## WEST SUSSEX COUNTY COUNCIL CONSULTATION

| <b>LOCATION:</b>           | Paynters Croft Burndell Road Arundel YAPTON BN18 0HR                                                                                                                                                                                                                                                                                                    |
| <b>SUBJECT:</b>            | F/36/26/OUT<br>Outline planning application with some matters reserved (except for access and layout) for the erection of 40 No dwellings with vehicular access from Burndell Road, provision of associated open space, alongside landscaping, drainage infrastructure and associated works. This application is a Departure from the Development Plan. |
| <b>RECOMMENDATION:</b>     | More Information                                                                                                                                                                                                                                                                                                                                        |

Drawing Status	Planning		
Client	Edge BP		
Project	Burndell Road, Yapton		
Drawing Title	Access Overview & Visibility Splays		
Scale	Date	Drawn by	Checked by
1:250	May 26	EMH	EJD
Drawing No.	2025-6804-001		Rev.
			C

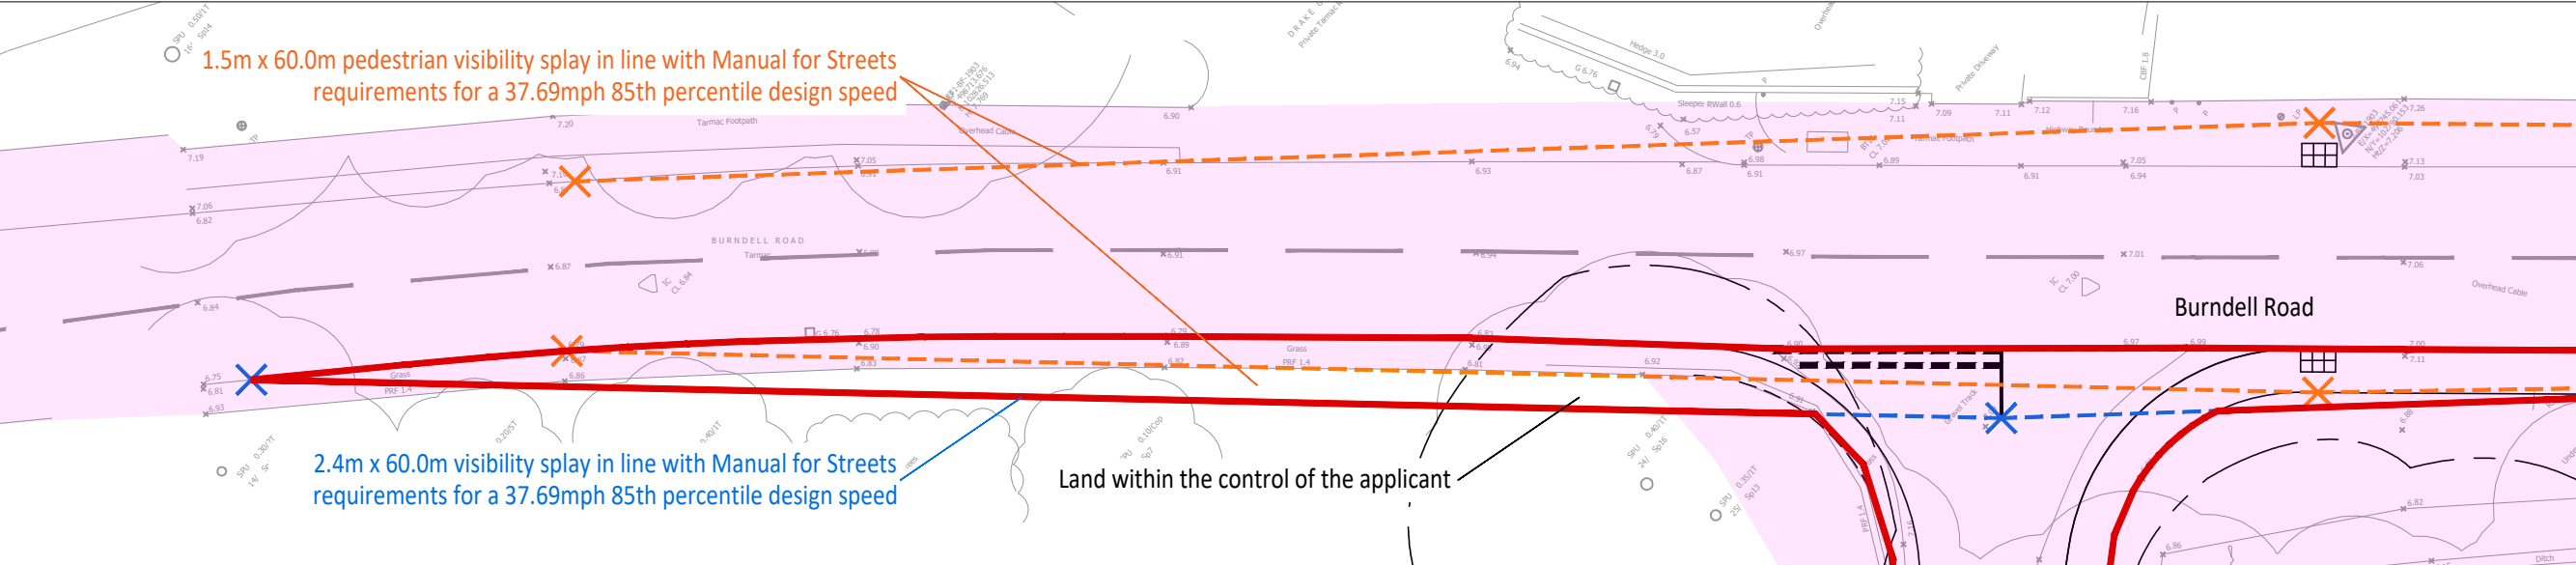
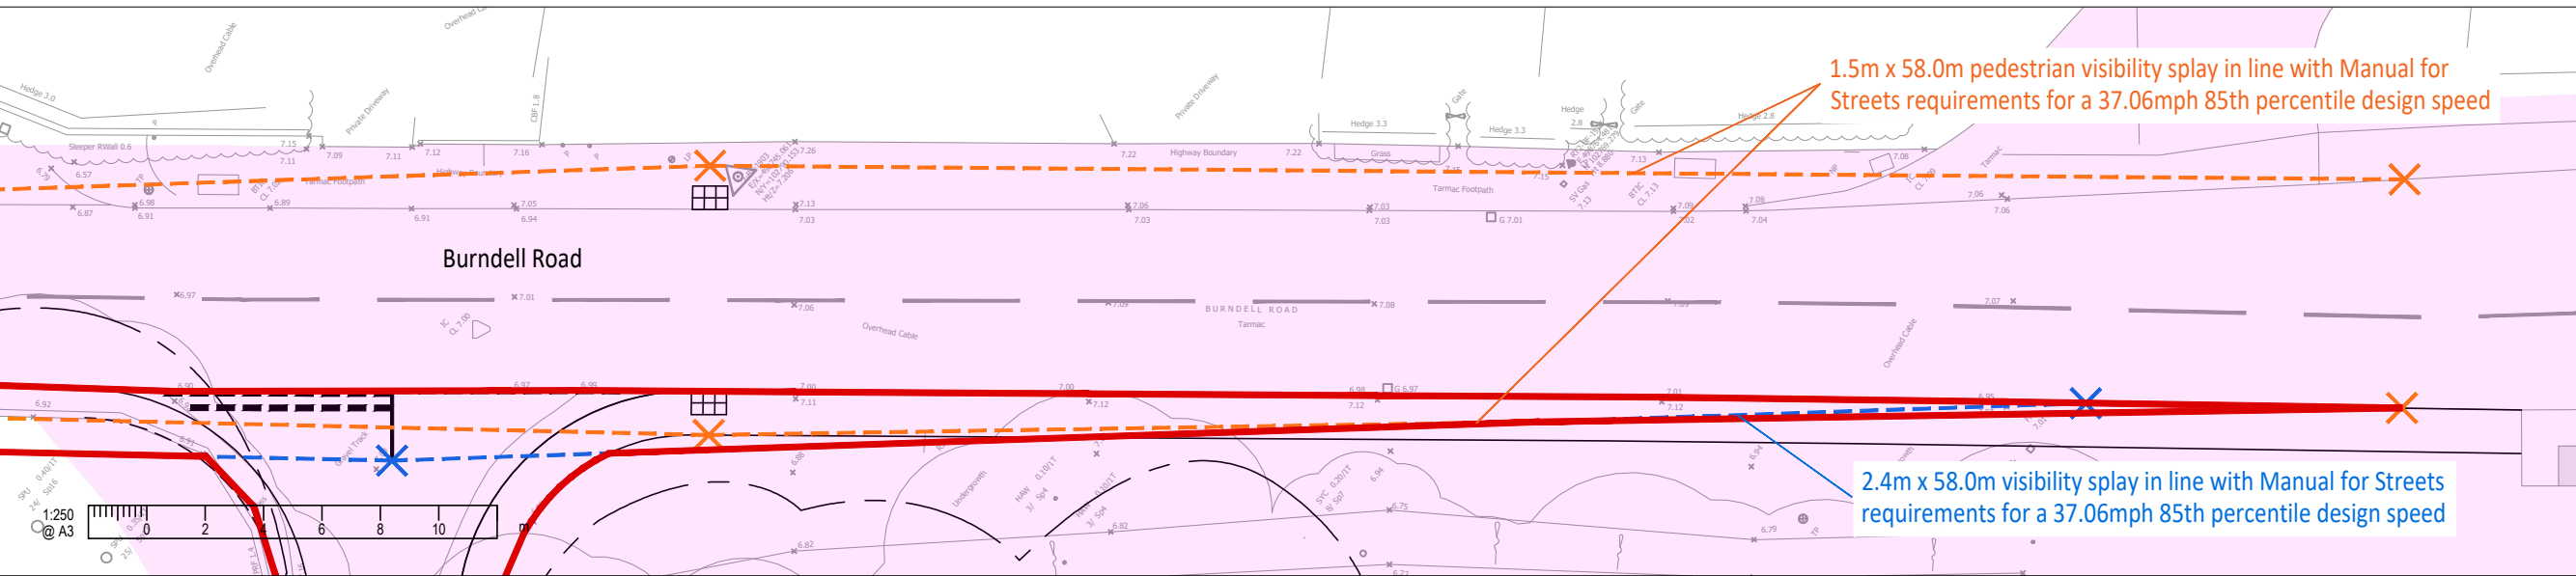
85<sup>th</sup> percentile speeds recorded under the previous application have been provided as 37.9mph northbound and 38.5mph. The Stopping Sight Distance (SSD) has been calculated using Manual for Streets 2 (MfS2) co-efficients rather than Design Manual for Roads & Bridges (DMRB). This is considered appropriate as per table 1.1 MfS whereby speeds of 40mph local context will be considered as to whether MfS principles should apply. Speeds are below 40mph, street lit footway, residential precedent and built up area and thus the LHA accept this method of calculating SSD which results in a splay requirement of 2.4m x 60m south and 62m north. The plans show splays of 60m north and 58m south and appears to be based on lower 85<sup>th</sup> percentile speeds (37.05mph northbound and 37.69mph southbound). Please amend the splays accordingly.

A pedestrian crossing point (dropped kerb/tactile paved) of Burndell Road is proposed south of proposed access and pedestrian visibility splays of 1.5m x 58m south and 60m north have been shown. The splays should be amended to accord with recorded 85<sup>th</sup> percentile speeds (60m south and 62m north). The TS states a 1.5m wide connecting footway is proposed to Rollaston Park bus stops to south

but this is not shown on the plans. Full extent of proposed linking footway should be shown on western side of Burndell Road linking from site access to Rollaston Park northbound bus stop as per comments in Accessibility by Non-vehicular modes section.

- Travel Plan Statement (or detail can be secured along with monitoring fee of £1765 via s106 agreement).
- Clarification/ plan of linking footway from site access to south Rollaston Park northbound bus stop (western side Burndell Road).
- Amended vehicular and pedestrian visibility splays (2.4m x 60m south and 62m north/ 1.5m x 60m south and 62m north)

Drawing Status	Planning		
Client	Edge BP		
Project	Burndell Road, Yapton		
Drawing Title	Delivery Van Access and Turning		
Scale	Date	Drawn by	Checked by
1:500	May 26	SMO	ALB
Drawing No.	2025-6804-005		Rev. B

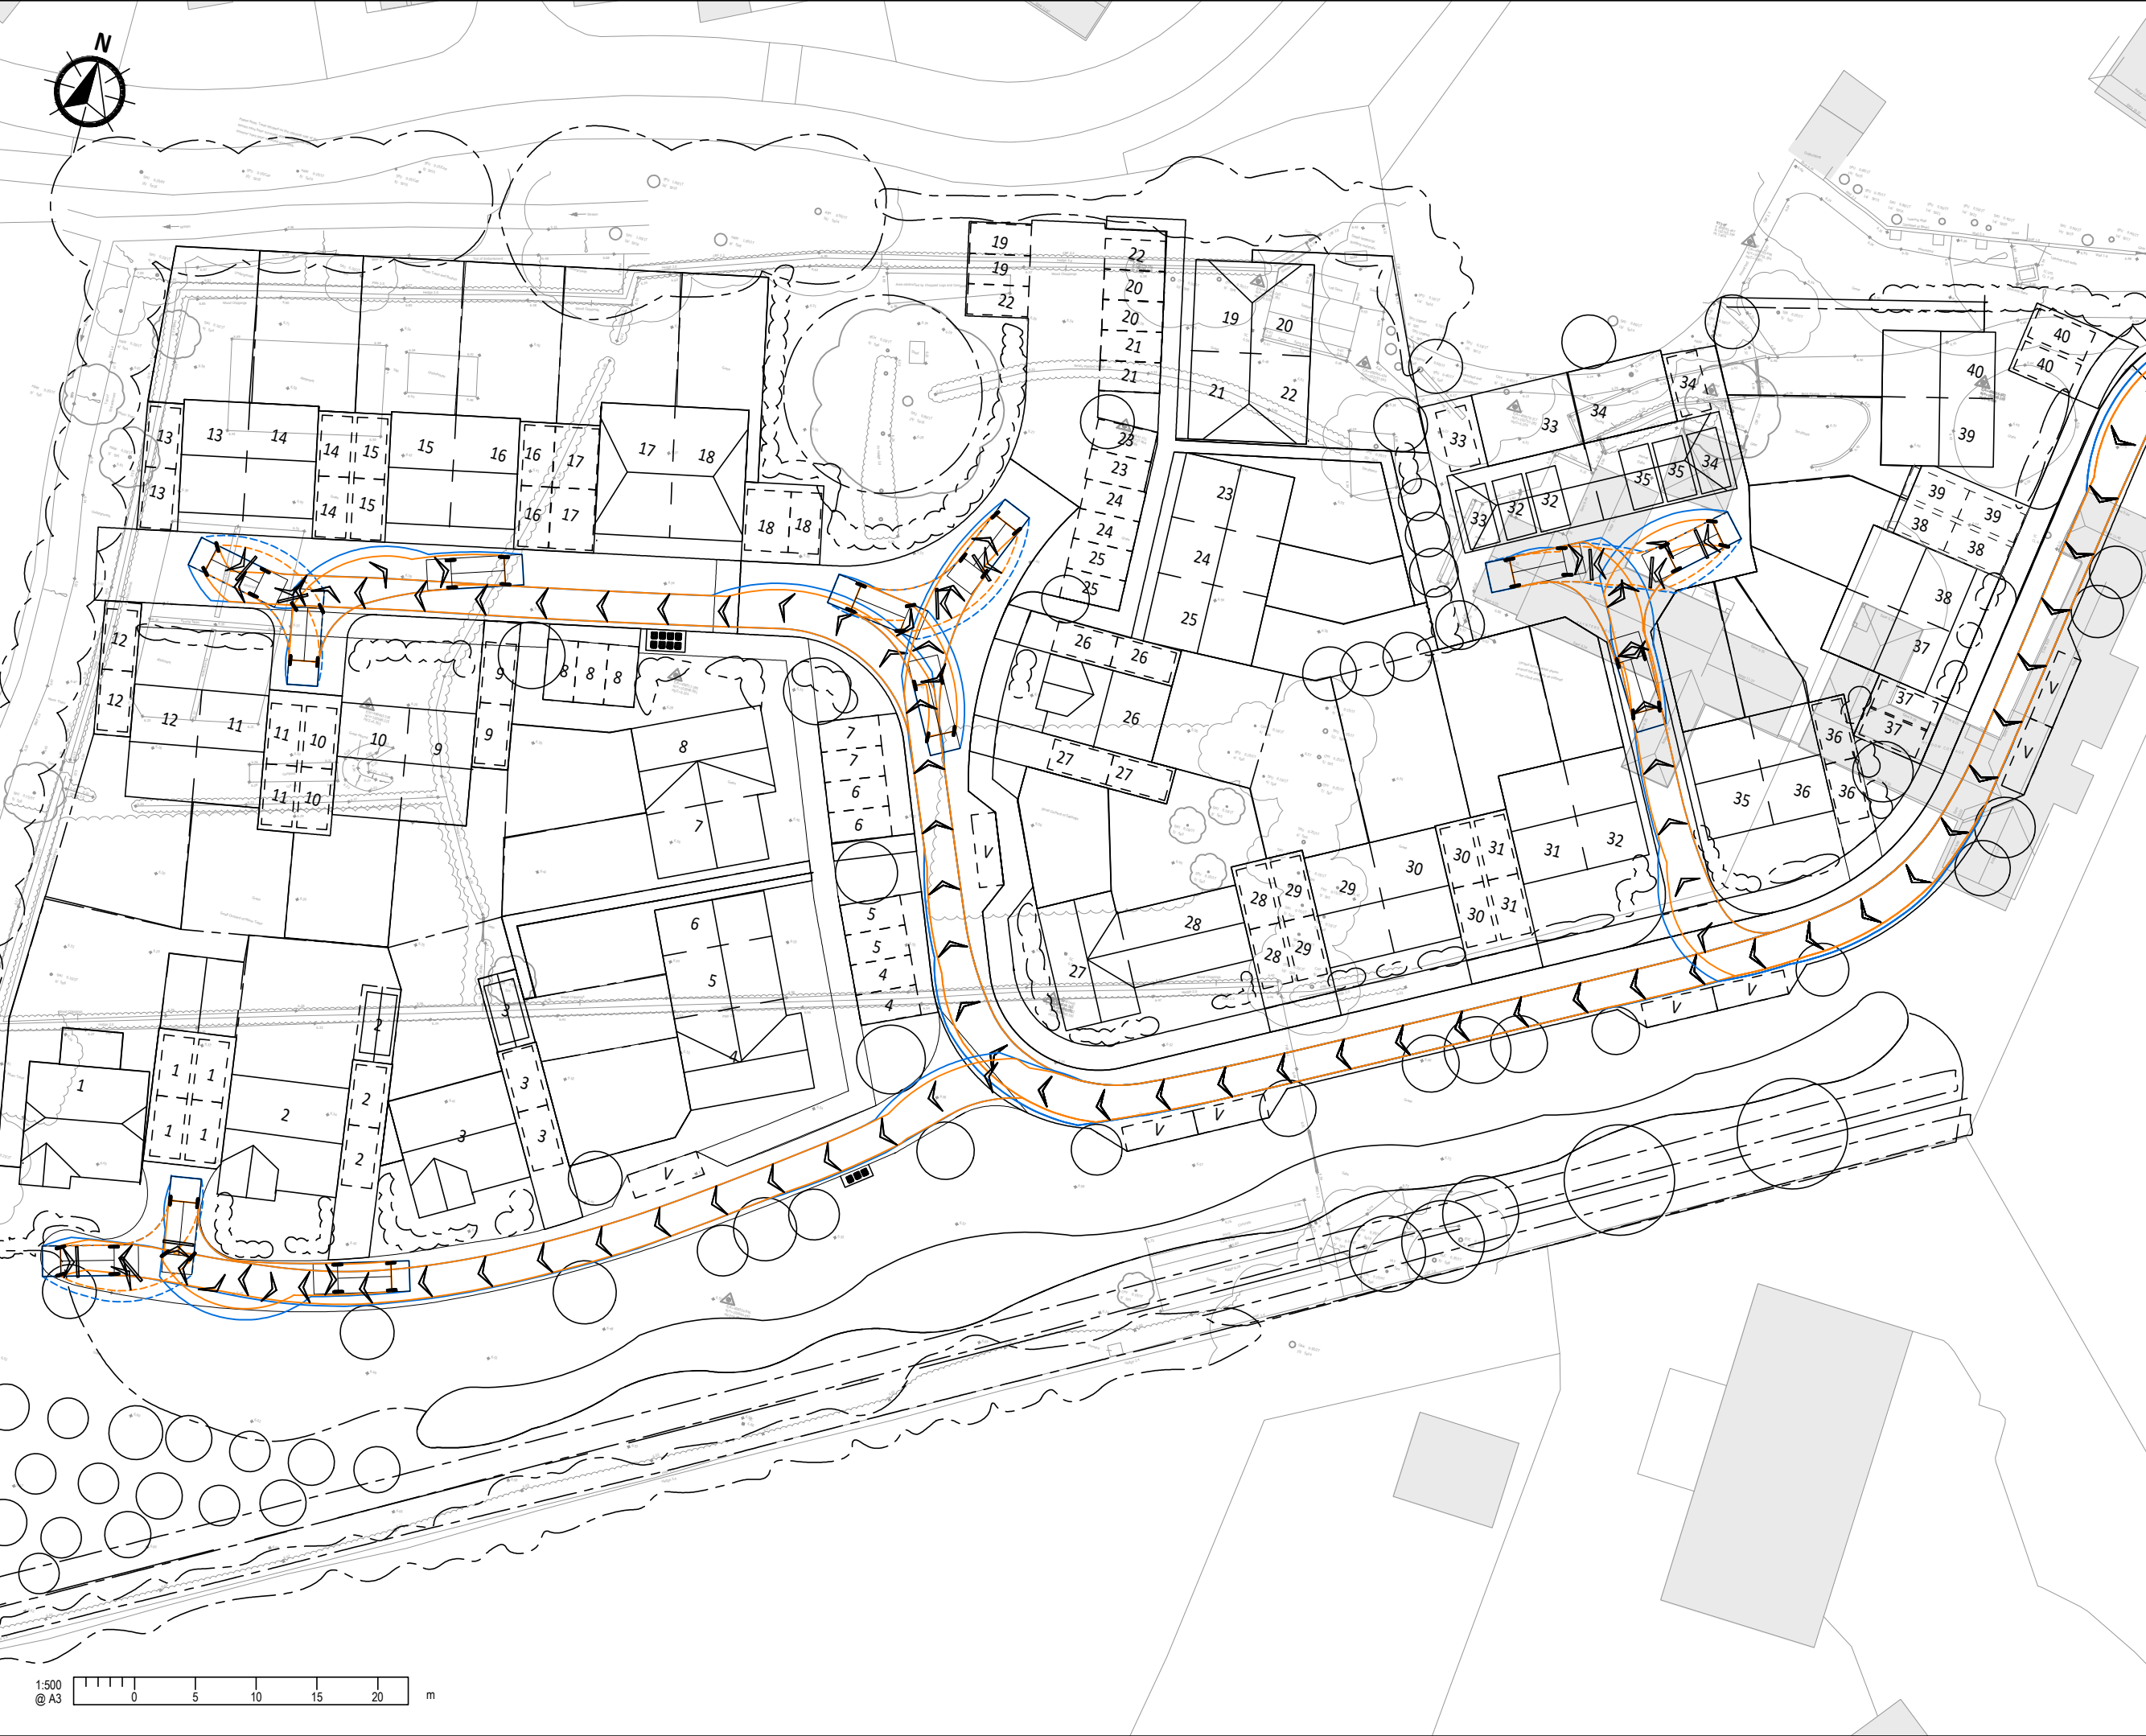
Swept path tracking shows two cars can pass within the site and turn to exit in a forward gear. Servicing vehicles (emergency servicing and refuse collection) can also undertake these manoeuvres. The tracking plan 'Refuse Vehicle Access' appears to show a light van in the key though actually tracking does appear to be for refuse collection vehicle.
